City of Albuquerque

Re: 630 Manzano NE Office Building dated 1/11/83
(J17-D5)

RE: Manzano Office Site for Coppedge/Weller

GRADING/DRAINAGE PLAN FOR
 630 MANZANO N.E.

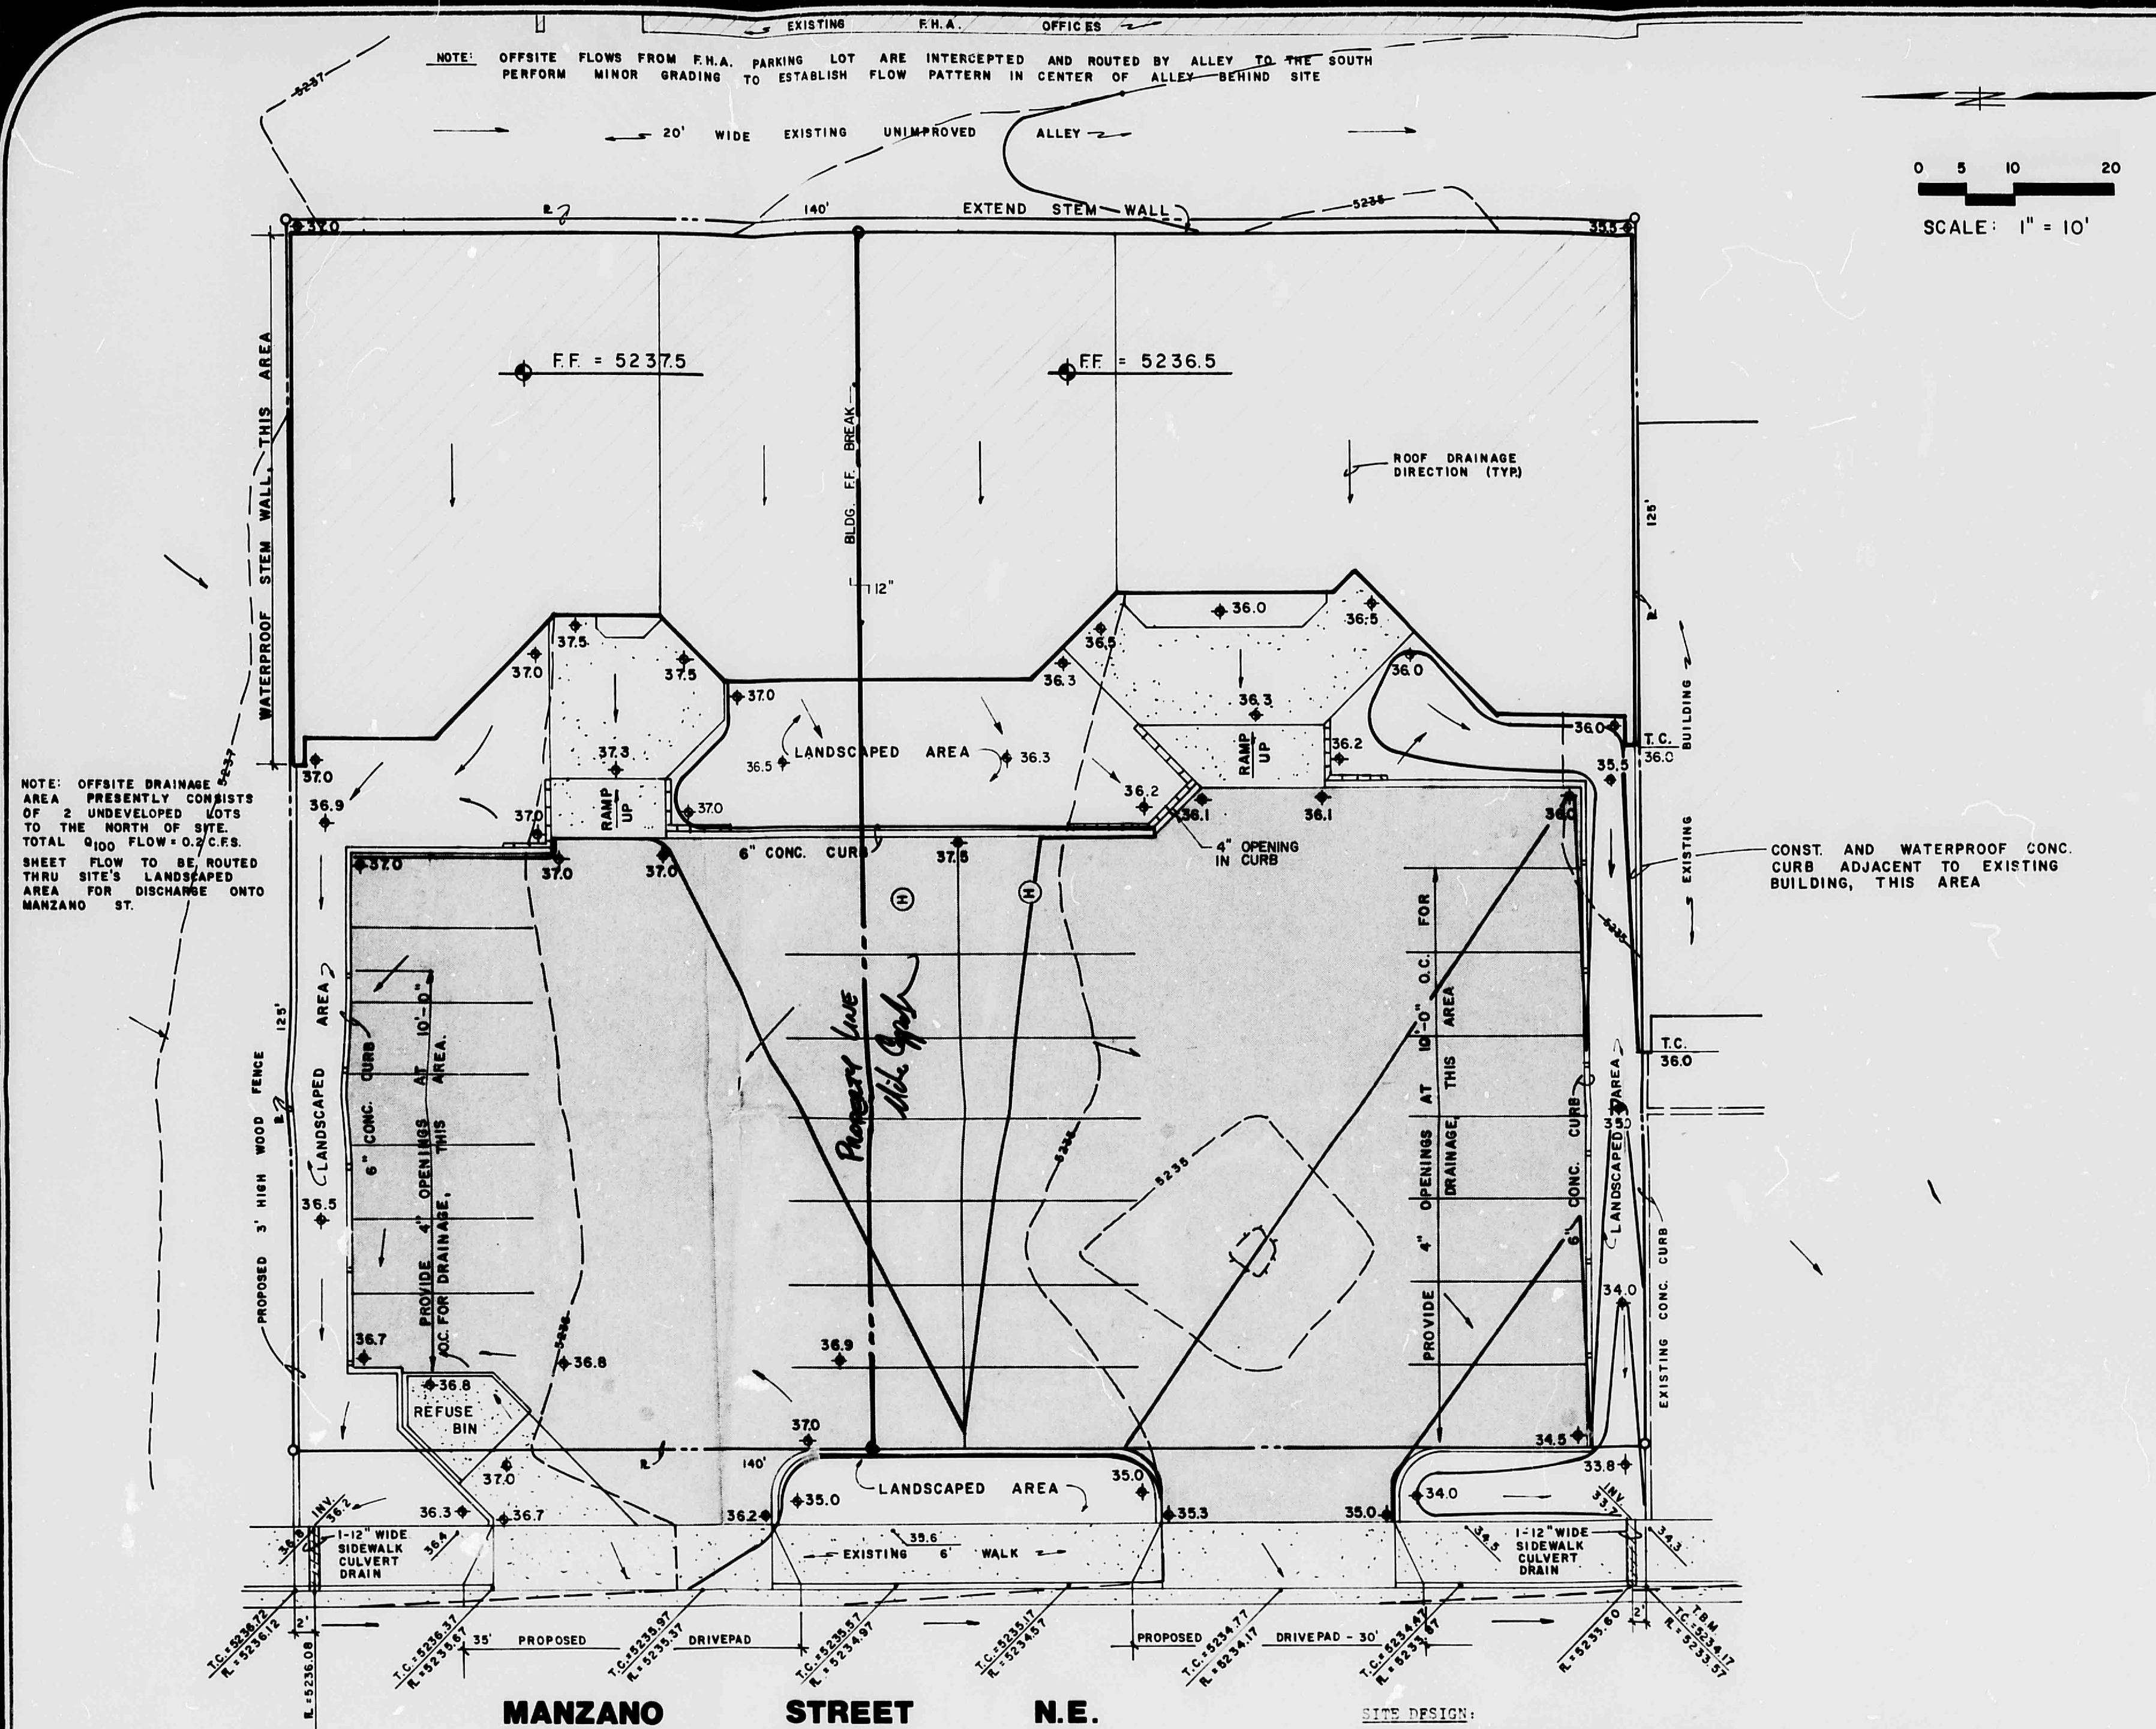
1. You had expressed concern about the nature of the impact that offsite flows from the north lot would have on the proposed building. The area generating these flows is small and presently undeveloped. The flows impacting the proposed building would be insignificant. Additionally, this building will have a water-proofed stem wall to further safeguard its stability. These flows will be routed to the proposed landscaped area for final discharge onto Manzano Street. Future development for the north area would undoubtedly route these flows directly to Manzano Street, away from this site.

2. You had also expressed concern about intercepting alley flows which presently drain across the area of the proposed office, and redirecting these flows south behind an existing office building. If these flows are diverted from their existing path, which presently intercepts the north side of this building, the situation will be improved. The flows can be routed south down the alley with no adverse affect because of existing paving behind and adjacent to this building. This pavement has a positive gradient away from the building, with the net effect of channelizing the alley flows away from the structure. The eventual outfall for the alley runoff, one way or the other, is Lomas Blvd.

The additional information provided in your letter dated 2/8/83 satisfies my concerns discussed with you earlier, therefore, your plan is approved.

The building plans for this project will be approved with the inclusion of this plan and a plat eliminating lot lines in the building set. If platting is not proposed, a private easement will be required for the proposed drainage across lot lines.
